WEST SUSSEX COUNTY COUNCIL CONSULTATION

TO:	Arun District Council FAO: Anita Gardner
FROM:	WSCC - Highways Authority
DATE:	5 June 2020
LOCATION:	16 Worthing Road Littlehampton BN16 1AZ
SUBJECT:	EP/48/20/DOC Approval of details reserved by condition imposed under ref EP/121/17/PL relating to Condition Nos 3 - materials & finishes, 4 - hard & soft landscaping, 6 - visibility splays, 7 - car parking spaces, 8 - pedestrian visibility splays, 10 - surface water drainage, 11 - SuDs, 13 - level survey and 15 - Construction Management Plan.
DATE OF SITE VISIT:	n/a /
RECOMMENDATION:	Advice
S106 CONTRIBUTION TOTAL:	n/a

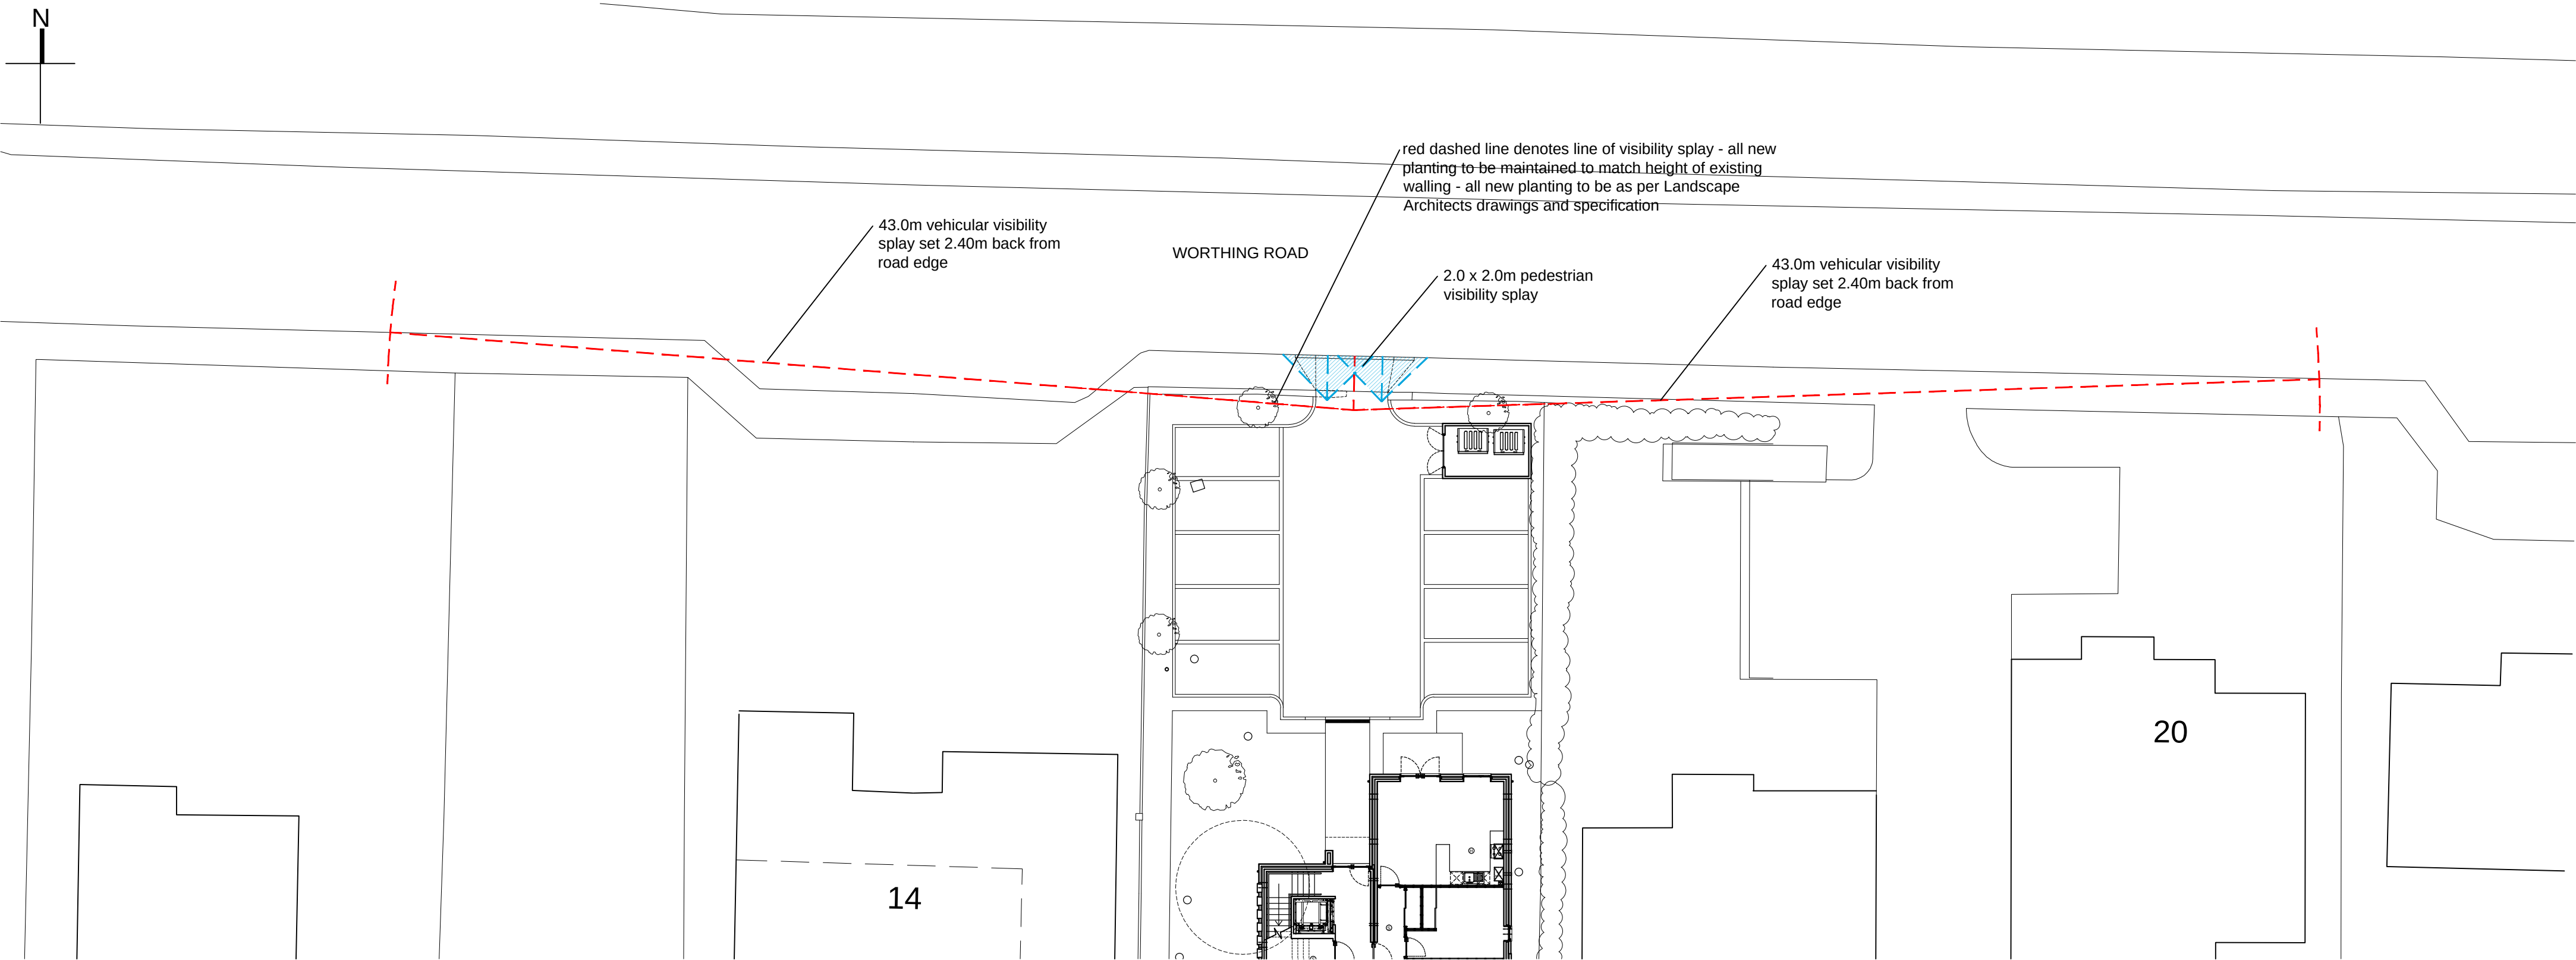
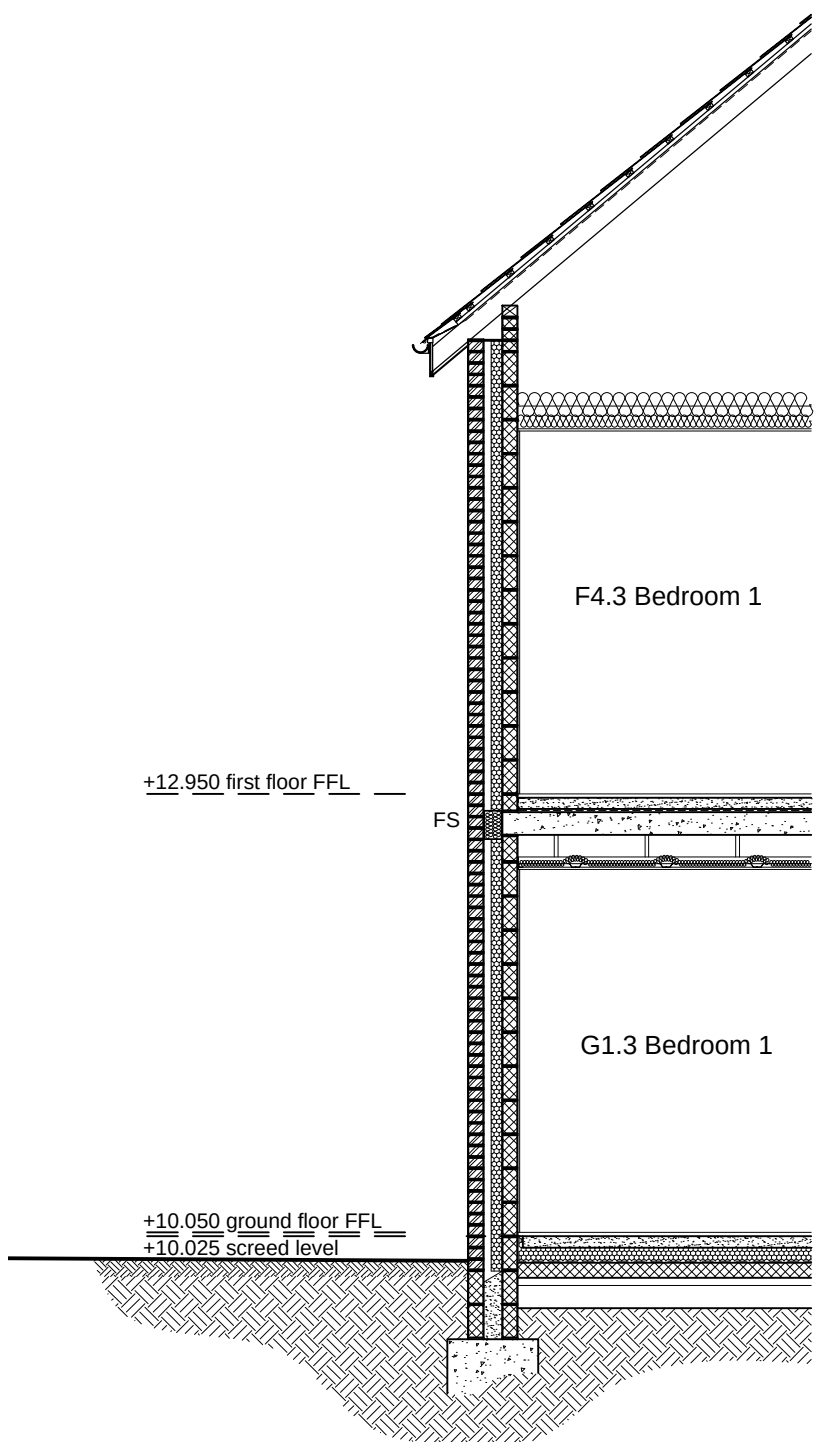
Condition 6 (Visibility Splays) - The condition requires visibility splays of 2.4 by 43 metres. These details are shown on drawing number 3.08, titled 'Planning Information Layout'. It's recognised that the splay to the west crosses a lay-by, giving the possibility of parked vehicles obstructing the splays. This matter was though identified and considered acceptable as part of the initial planning application.

Condition 8 (Pedestrian Visibility Splays) - The details as shown on drawing number 3.08, titled 'Planning Information Layout' are considered acceptable. Condition 8 can be discharged.
